ENG-SP20008-R4-GEC-redlines.pdf Markup Summary

SHEET 3 OF 10
JOB NO. 25188.00

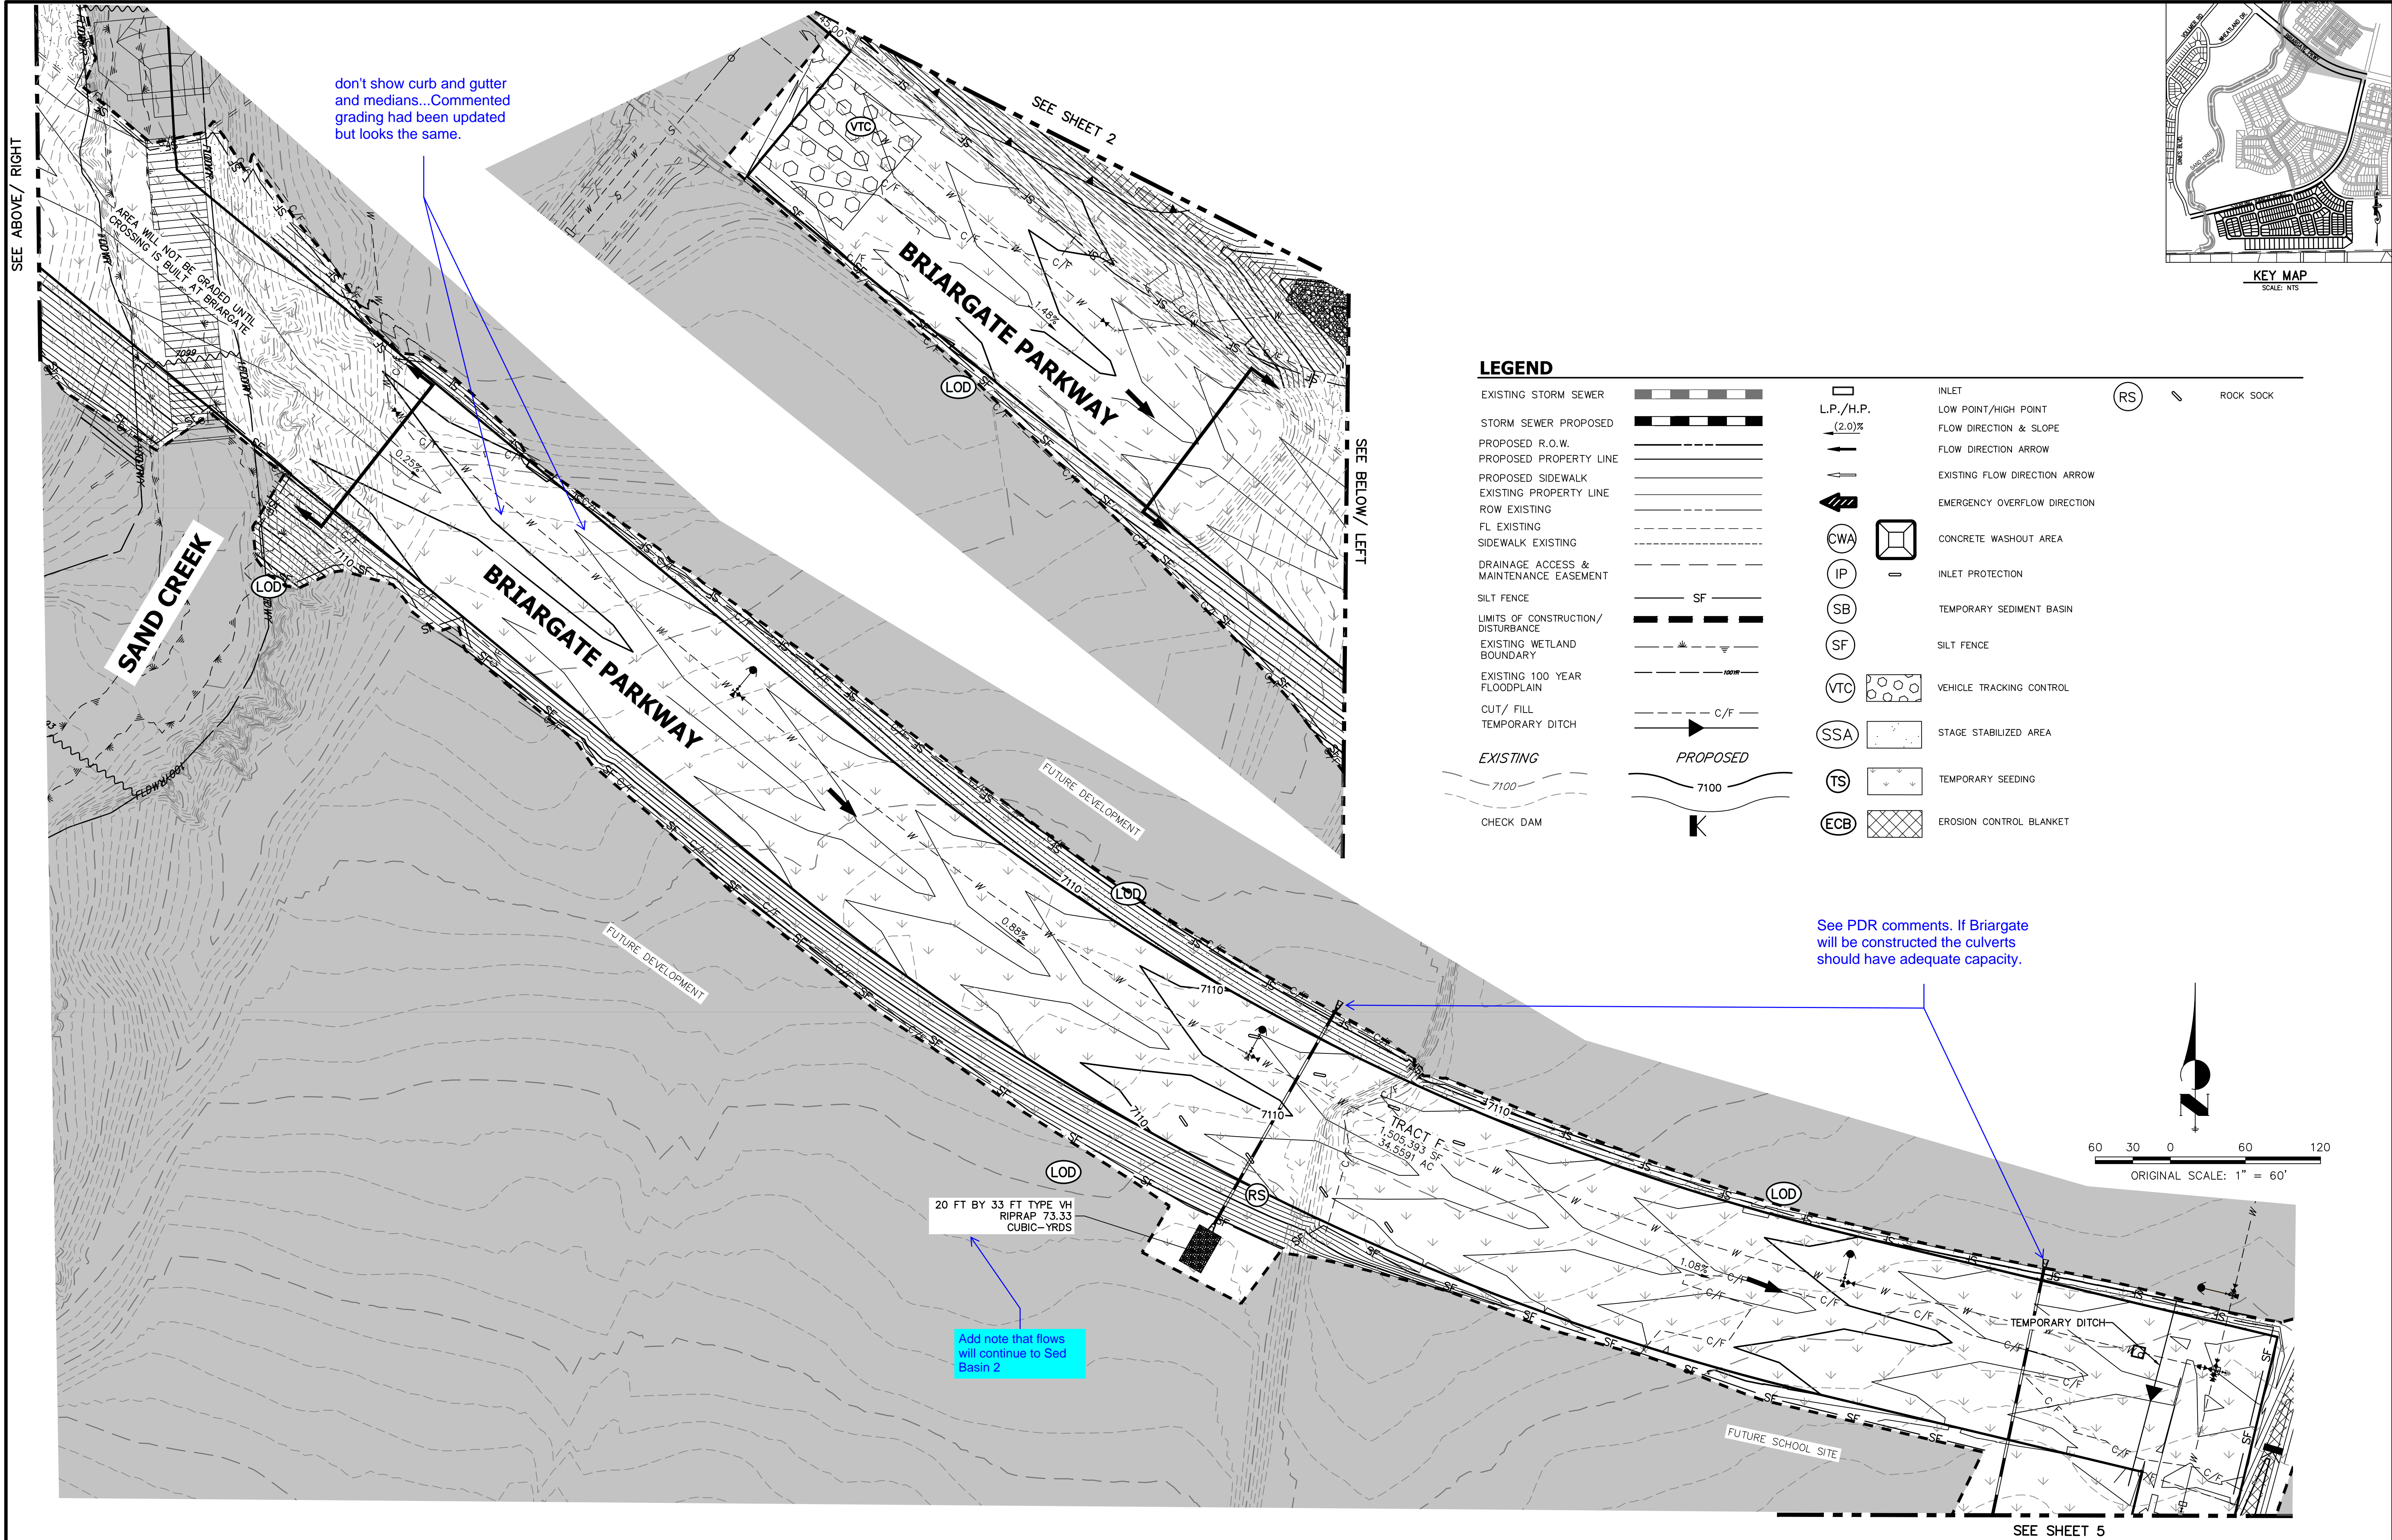
don't show curb and gutter and medians...Commented grading had been updated but looks the same.

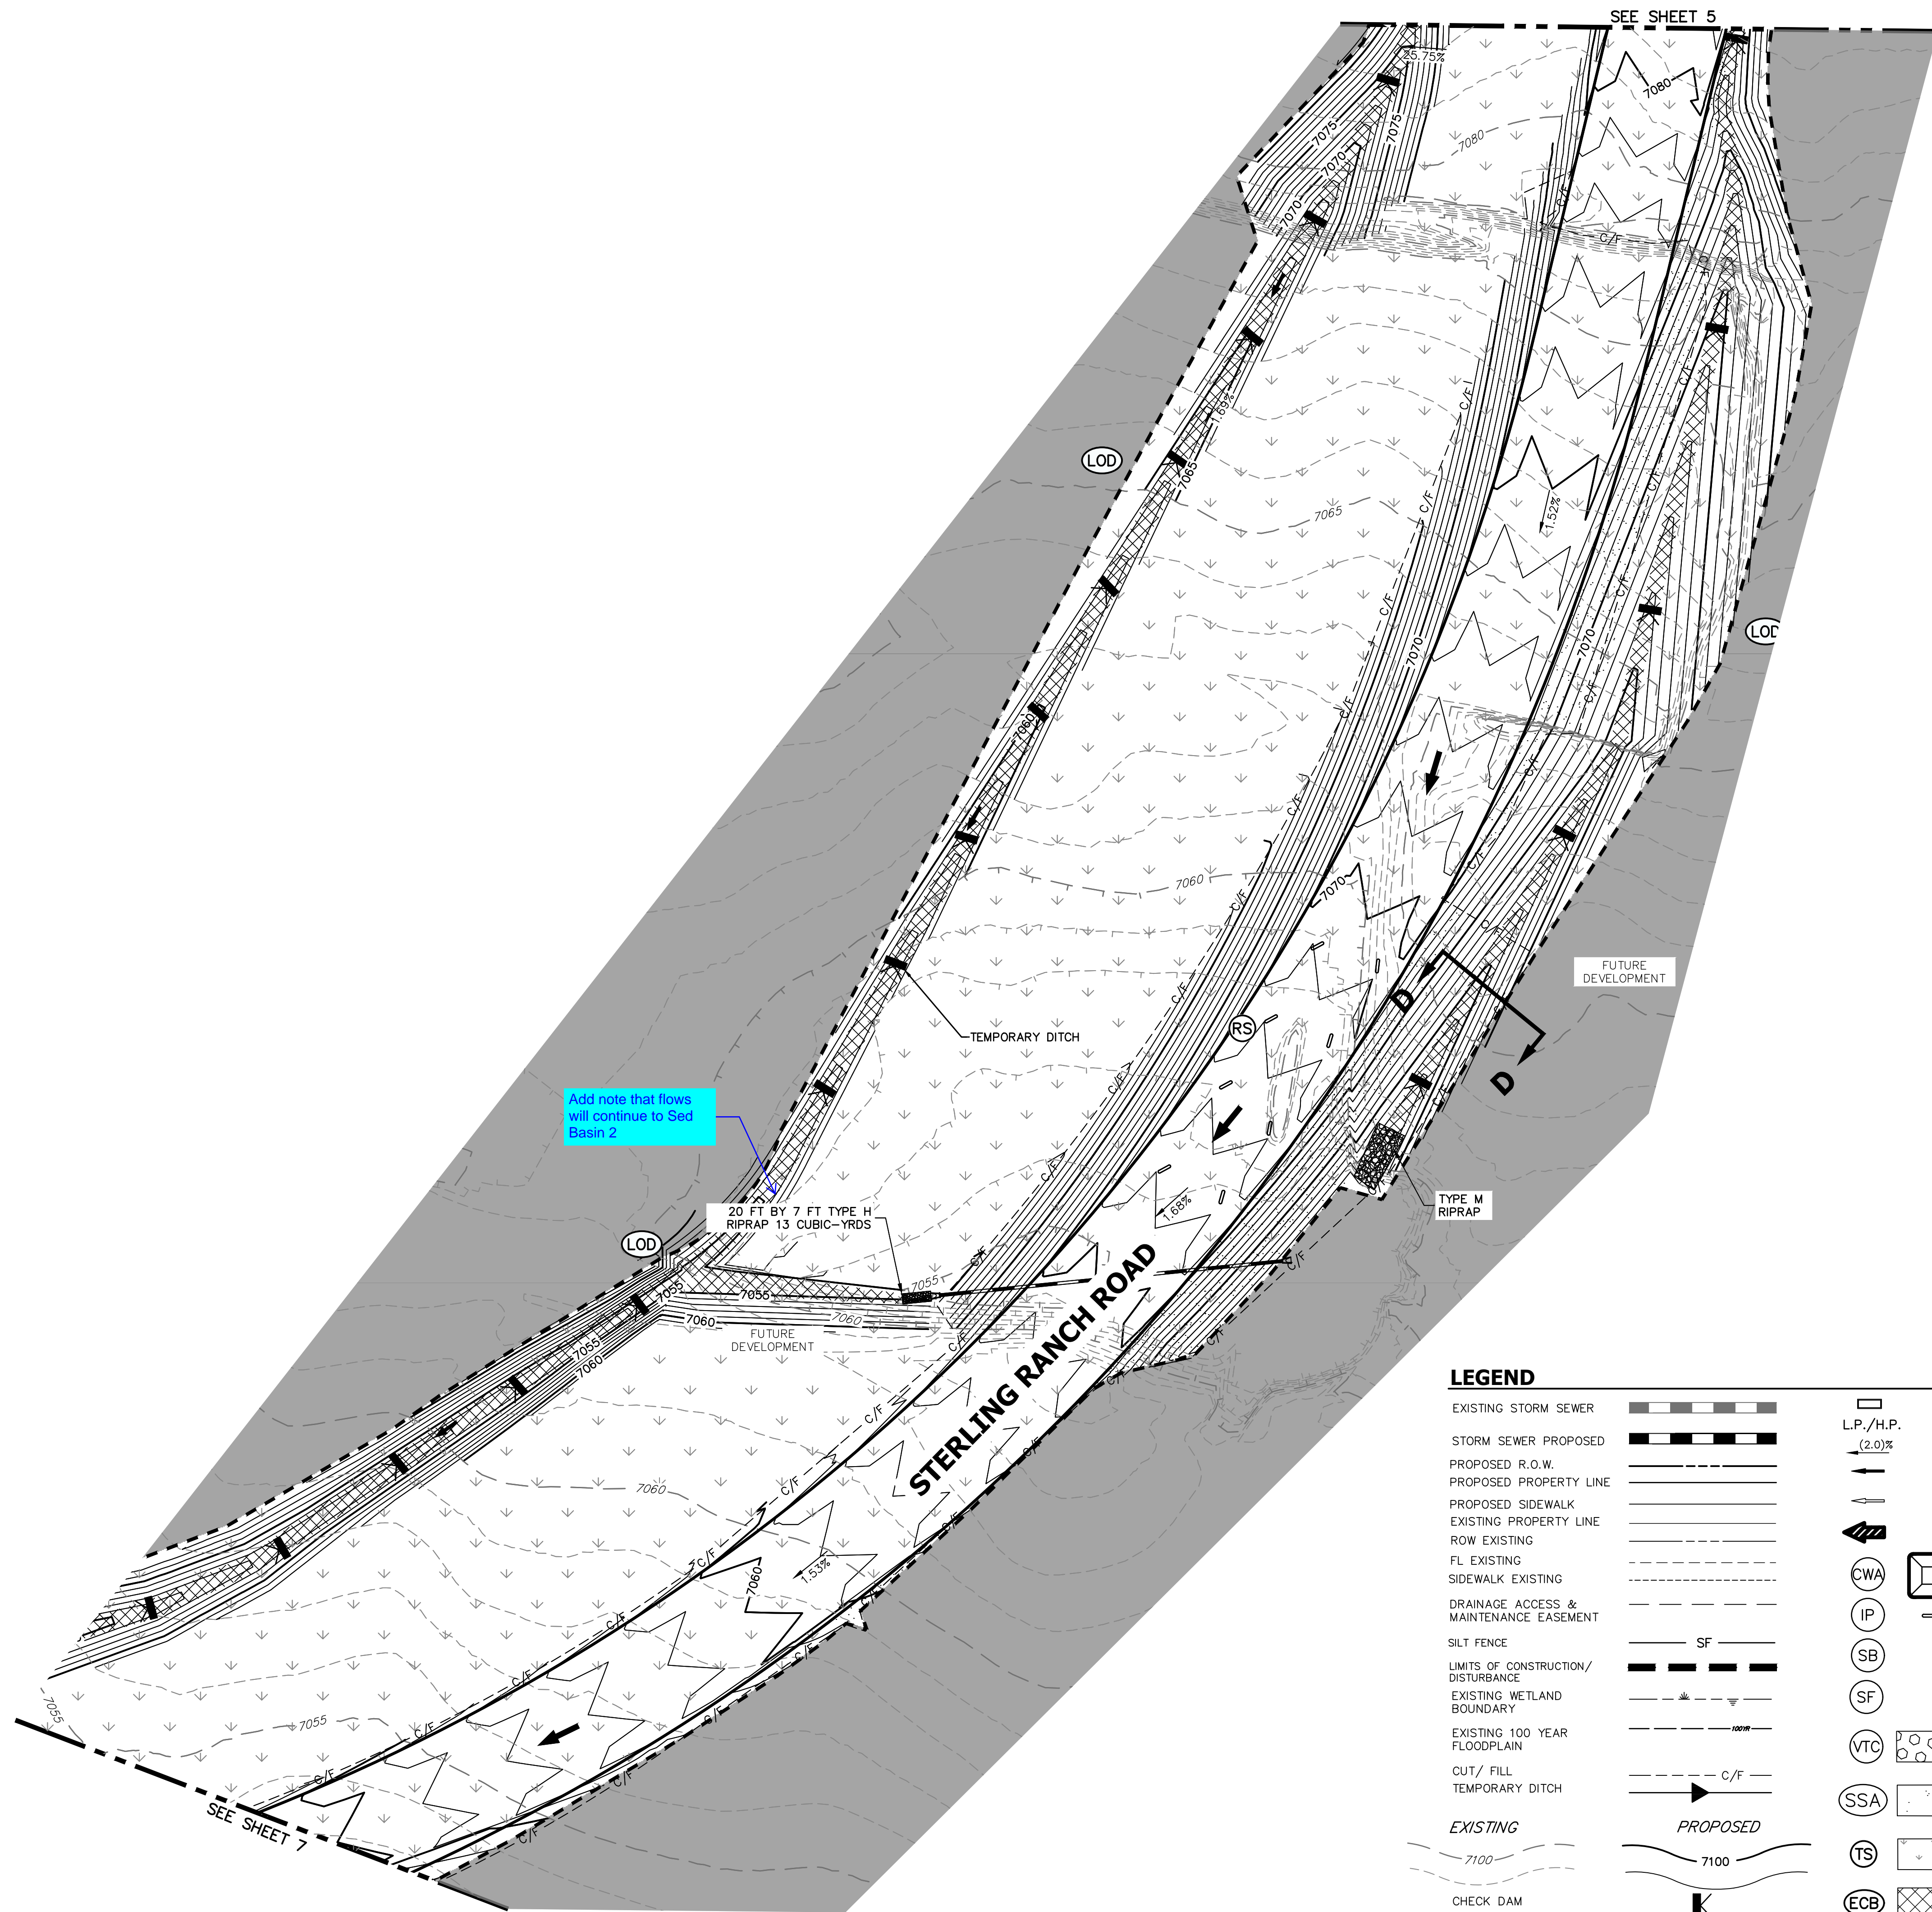
Add note that flows will continue to Sed Basin 2
